Rezoning Transportation Analysis
Petition Number: Insert Zoning Petition #2021-056
General Location Identifier: 04105416

Revision Log:

Date	Description
05-27-2021	First Review (EL)
08-24-2021	Second Review (BB)

Drawing No. **RZ-1.0**

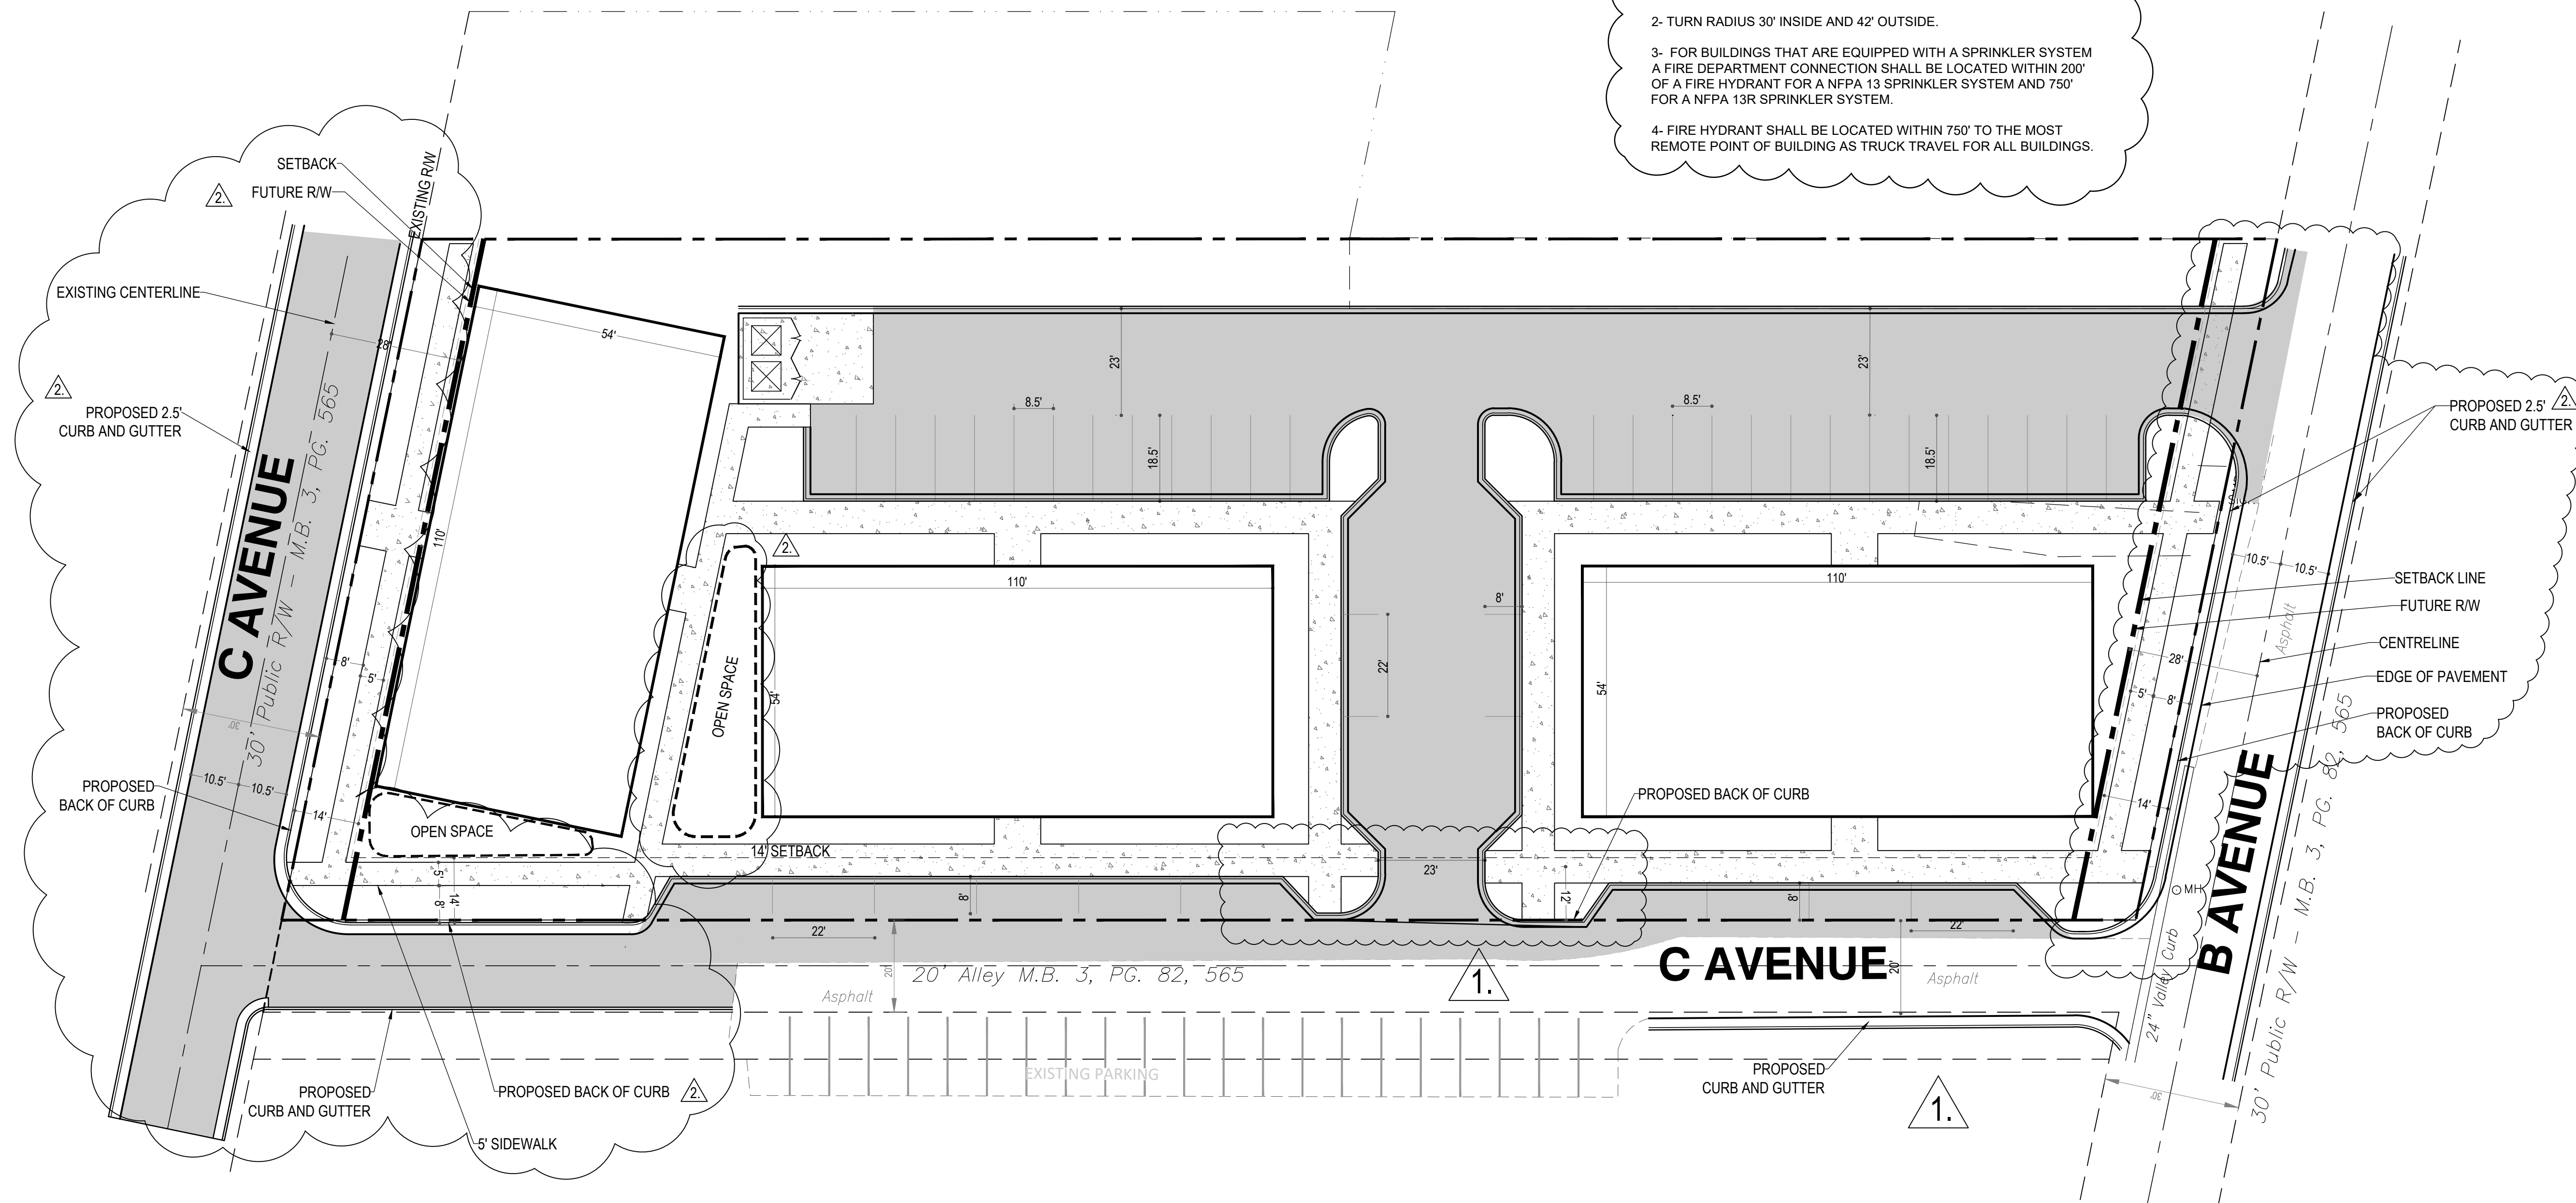
- c. **Outstanding Comment: Alleyway/Paper Right of Way:** Construct a CLDSM standard detail number U-03 – *Local Residential Wide Street Typical Section* (for the portion highlighted in blue) along the property frontage of alleyway/paper right of way. 8-foot planting strip and 8-foot sidewalk is only required along this rezoning site's property frontage since DUA is greater than 12.

Label and dimension the curb and gutter and proposed right of way from the centerline for each road on the site plan.

- Outstanding Comment:** Revise site plan and conditional note(s) to commit to dedicate 35.5-feet of public right-of-way from the alleyway centerline, if public right of way is already platted. The site plan shall label and dimension the right-of-way from the road centerline, per CLDSM standard detail number U-03 – *Local Residential Wide Street Typical Section*. If this is confirmed to only be a 20-foot wide alleyway, coordinate with CDOT to determine the appropriate requirements.

- Outstanding Comment:** Revise site plan and conditional note(s) to commit to construct an 8-foot planting strip and 8-foot sidewalk on all public street frontages per Chapter 19 / Chapter 20 of the City Code and the Charlotte WALKS Council-adopted policy. 8-foot sidewalk is needed since more than 12 dwelling units per acre is proposed. The site plan shall label and dimension both items from the back of curb and gutter and road centerline.

- 6. **Outstanding Comment:** Revise site plan and conditional note(s), including Site Plan Conditional Note 3.a, Access, Transportation, and Improvements to extend the Residential Wide typical section on the alleyway / paper right of way to North Avenue (now labeled as C Avenue).

- 7. **Outstanding Comment:** Revise site plan and conditional note(s) to commit to construct two PROWAG ramps at the alleyway / paper right of way intersections with North Avenue (now labeled C Avenue) and B Avenue.

- 8. **Outstanding Comment:** A site plan note(s) specifying dedication and fee simple conveyance of all rights-of-way to the City before the site's first building certificate of occupancy is issued is needed. CDOT requests rights-of-way set at 2' behind back of sidewalk where feasible.
